KIRKLEES METROPOLITAN COUNCIL INVESTMENT & REGENERATION SERVICE

DELEGATED DECISION TO DETERMINE PLANNING APPLICATIONS

Reference No:	2025/62/90644/W
Site Address:	Mount View, Sheffield Road, New Mill, Holmfirth, HD9 7HA
Description:	Demolition of existing conservatory and erection of single storey rear extension, erection of replacement garage, porch to front elevation, and associated external alterations
Recommending Officer:	Molly Storer

DECISION – CONDITIONAL FULL PERMISSION

Proposed Plans and Elevations of Garage and Garden Room		
project number	drawing number	revision
116	212	A

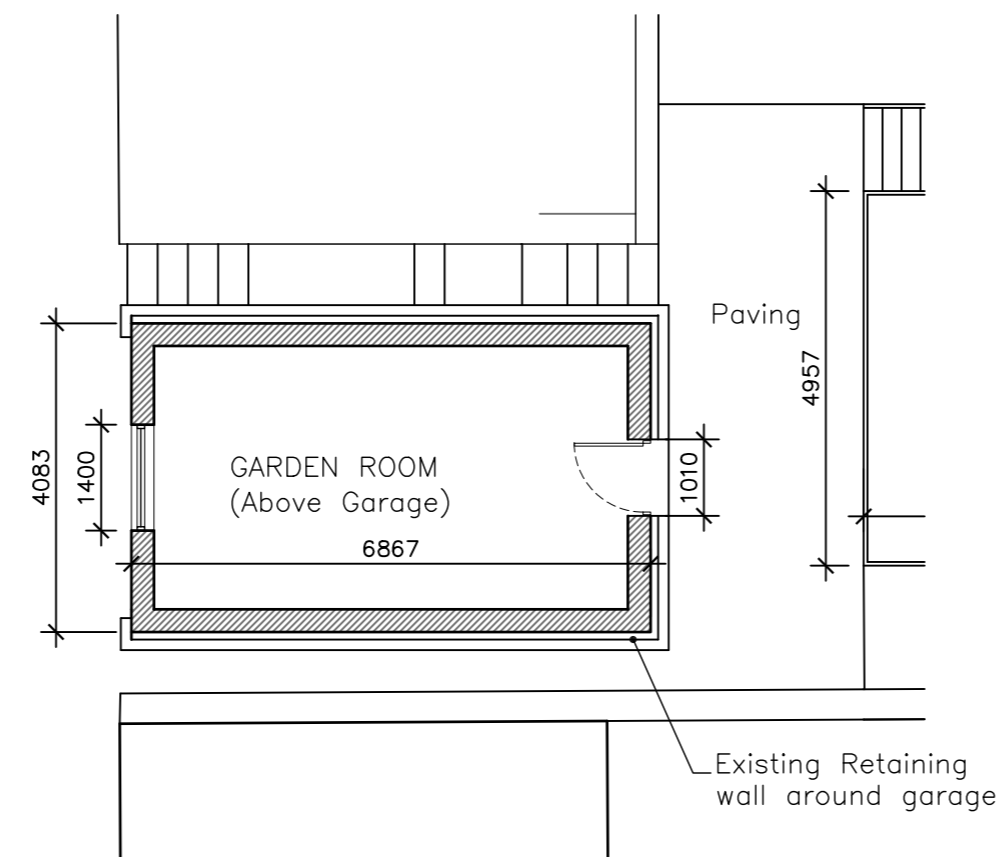
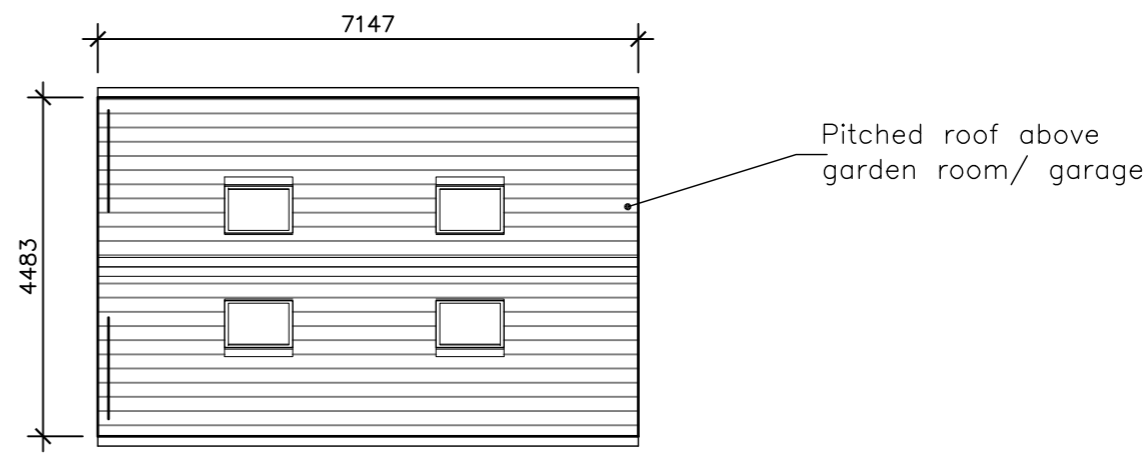
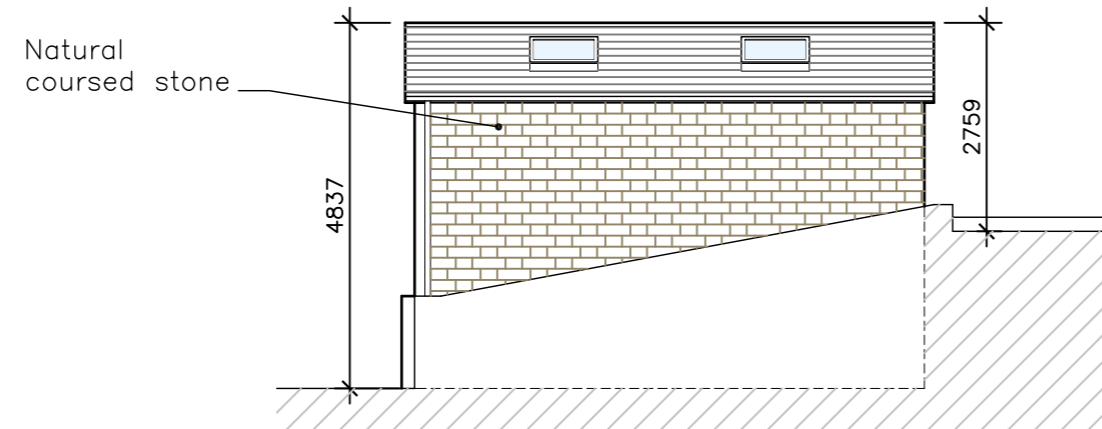
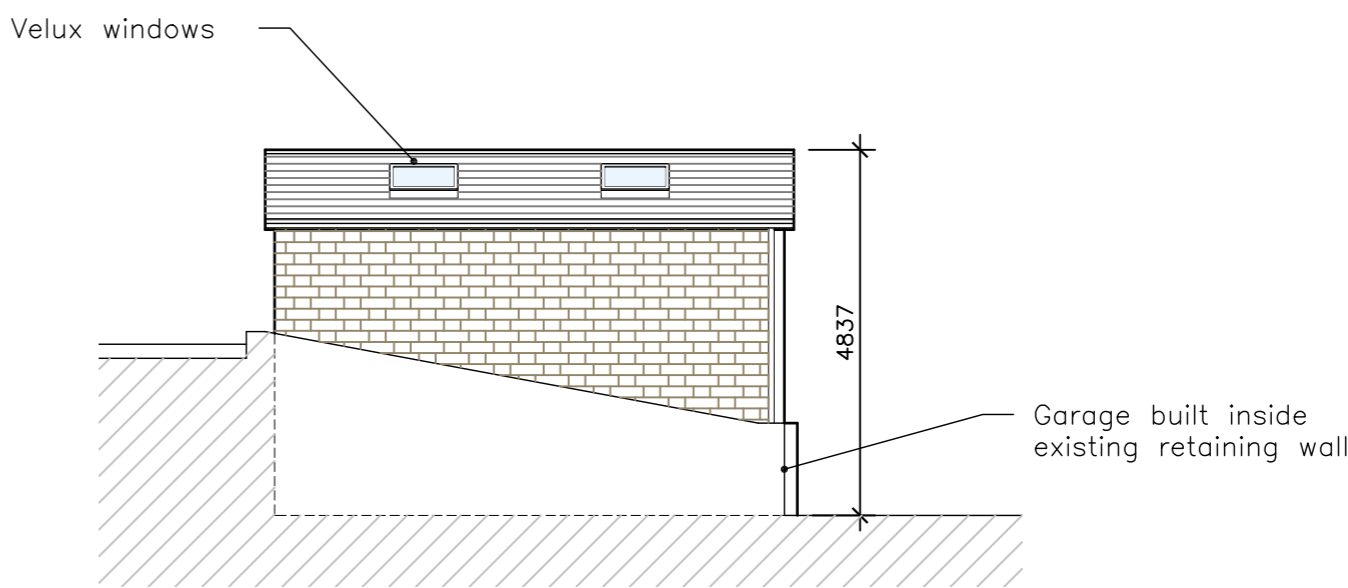
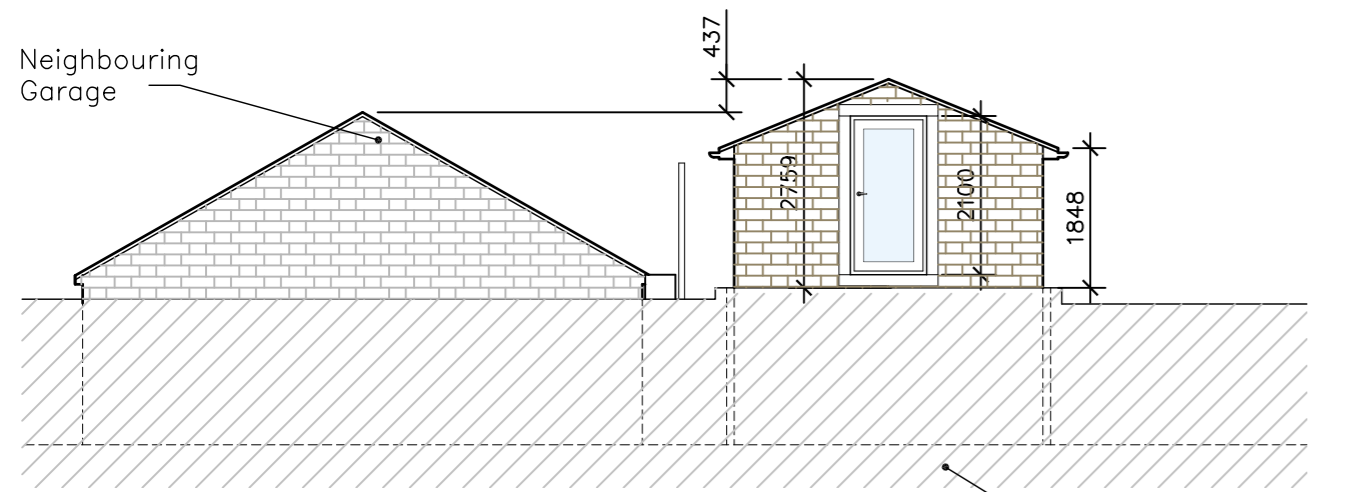
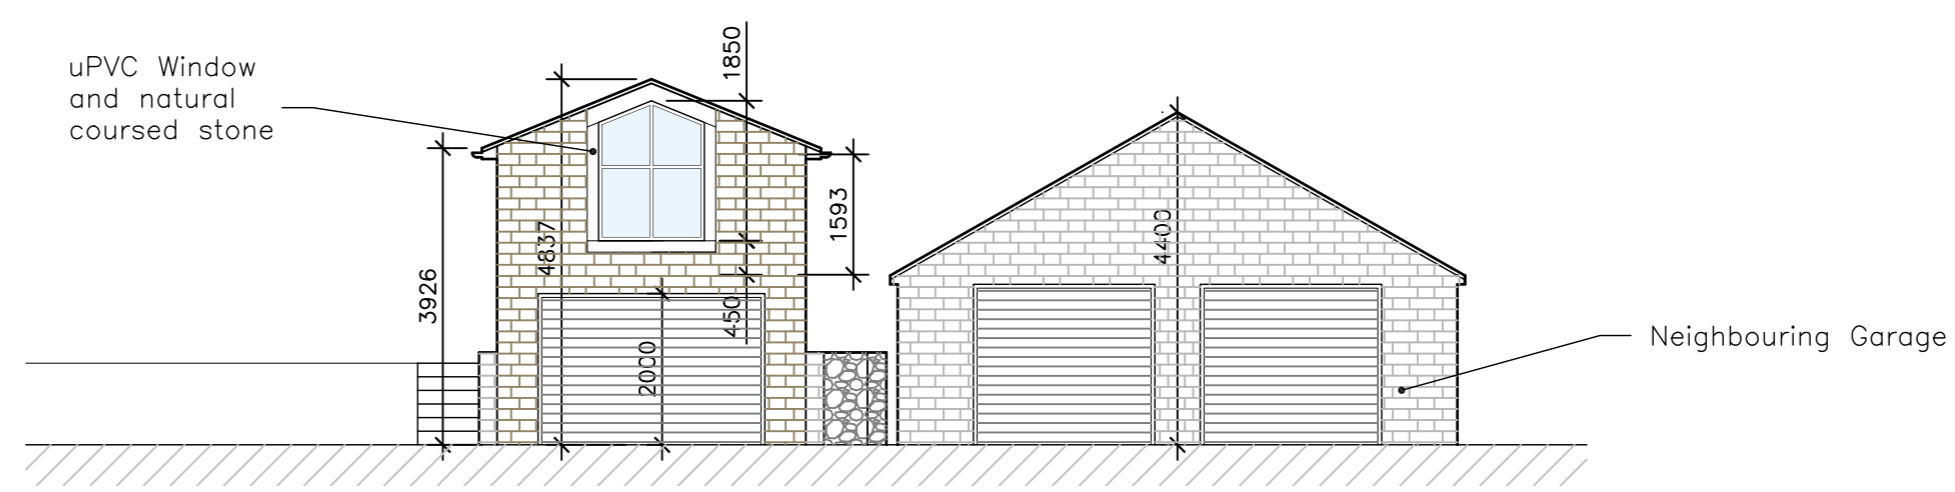
The existing single storey garage is of a pre fabricated concrete material of construction and flat roof design. and the existing 3.75m x 4m shed will be removed and replaced with a garage/garden room. This will involve constructing a replacement garage which will be accessed off Wildspur Grove with a garden room above which will be accessed from the rear garden of the site. This will measure:

- 7m in length
- 4.8m in width

- 2.76m to eaves when viewed from the rear garden
- 3.8m to eaves and 4.837m overall height when viewed from Wildspur Grove
- Gable roof design

The garage will be 2m of this height and the garden room on top of this will be 2.837m.

increase was included in the calculations. Overall the percentage increase would be 85%. It is considered that this would be of a scale, in terms of additional built form alone, which would constitute a disproportionate addition. In addition, the replacement garage would be the replacement of a building which is materially larger than the one it replaces, and this exception would also not be applicable.

The replacement garage would be larger than existing, seeing the addition of a garden room accessed via the rear garden. Although this would be a two storey addition, it would appear subservient to the existing property due to land level changes at the site. The overall height would not exceed the eaves height of the original property and would match the height of neighbouring garages. Due to the garage being built on the same footprint as existing no further garden space would be taken up and it would be set significantly back from the front of the property. Therefore, this element is considered acceptable.

Due to the garage being located to the opposite side of the site and having no windows in the elevation facing this property this element is not considered to have a significant impact to this property. The single storey rear extension and porch will have no windows in the elevation facing this property and will have a separation distance of 1.75m and 5m respectively. Due to this and both elements being single storey in height it is not considered to have a significant impact. Furthermore, Mayfield projects significantly further to the rear than Mount View and therefore will not be significantly impacted by the rear extension.
